From: Amy Myer <Amy.Myer@arun.gov.uk>
Sent: 28 February 2020 17:56
To: Planning.Responses <Planning.Responses@arun.gov.uk>
Subject: FW: P/1/20/PL - 209 Pagham Rd - CONSERVATION COMMENTS

P/1/20/PL

209 Pagham Road Pagham PO21 3QD Extension of existing flat to create 1 No. dwelling house.

DRAWING TITLE
Location, block and site plans

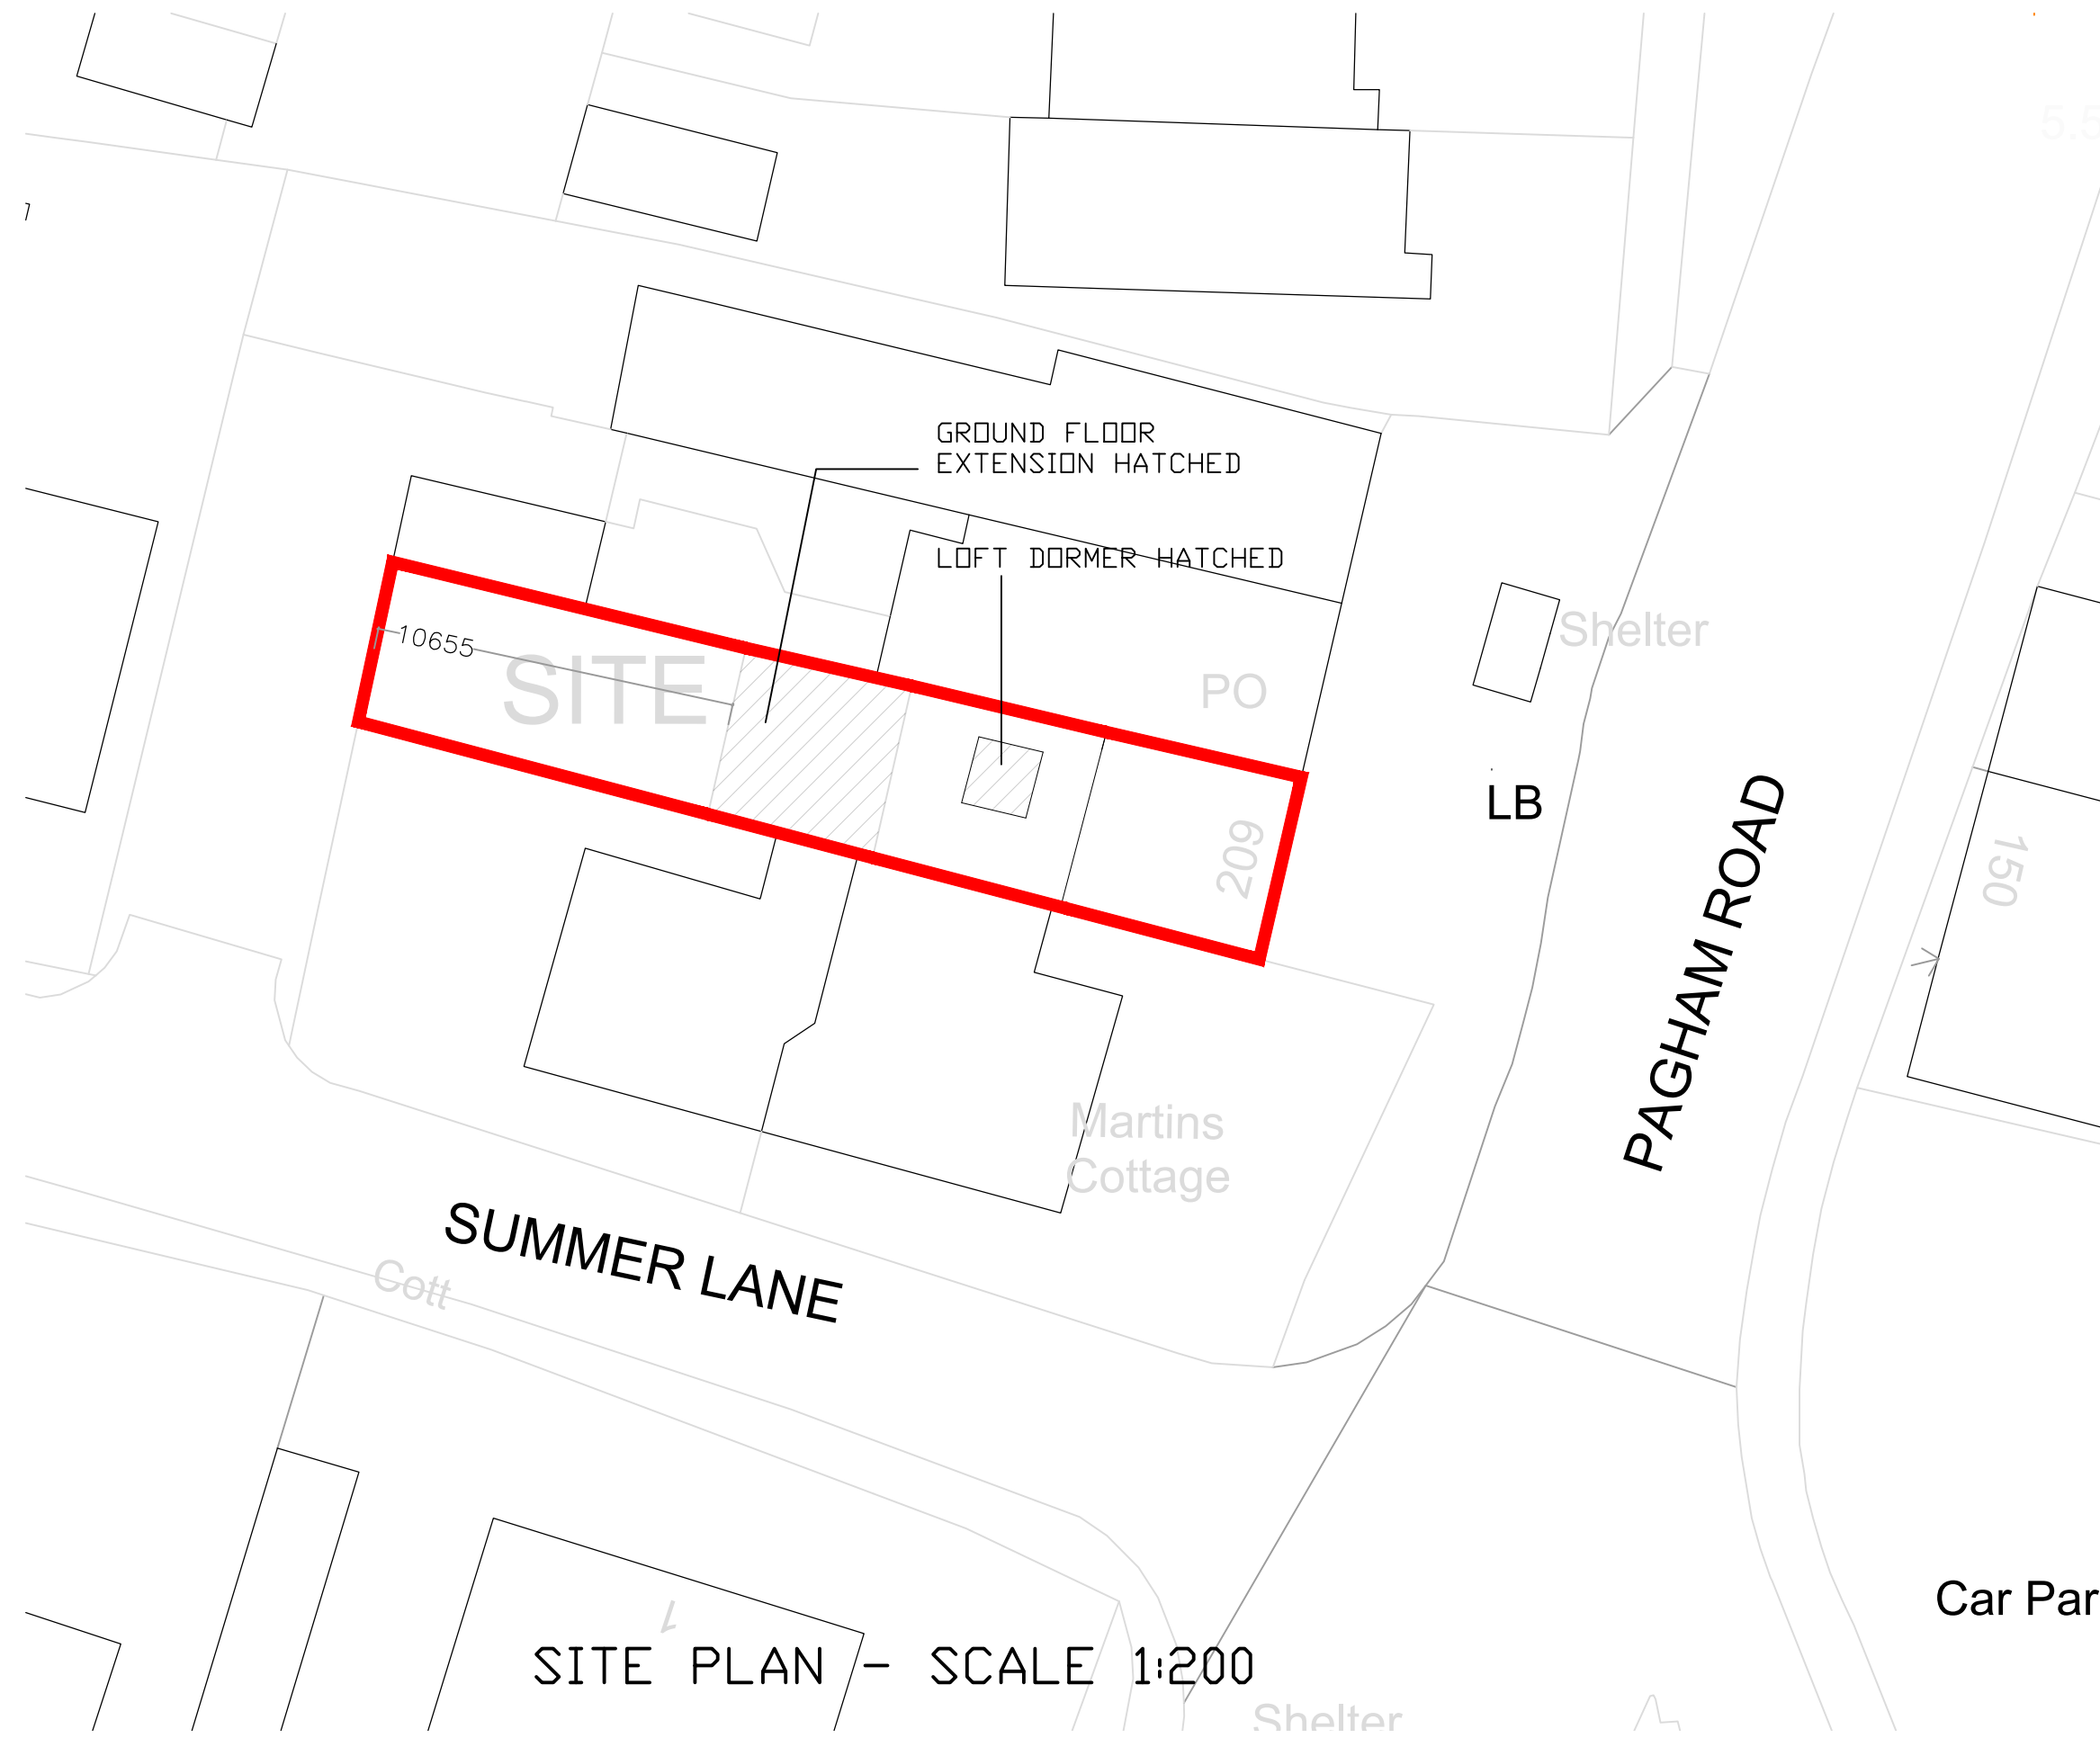
It would appear that the rear extension will abut the curtilage wall of the neighbouring listed building. Development proposals such as this should ensure that they do not harm the wall either during construction, or afterwards through the design or use of materials.

If you are minded to approve the proposal, the applicant should submit details of how the wall will be protected during the construction works.
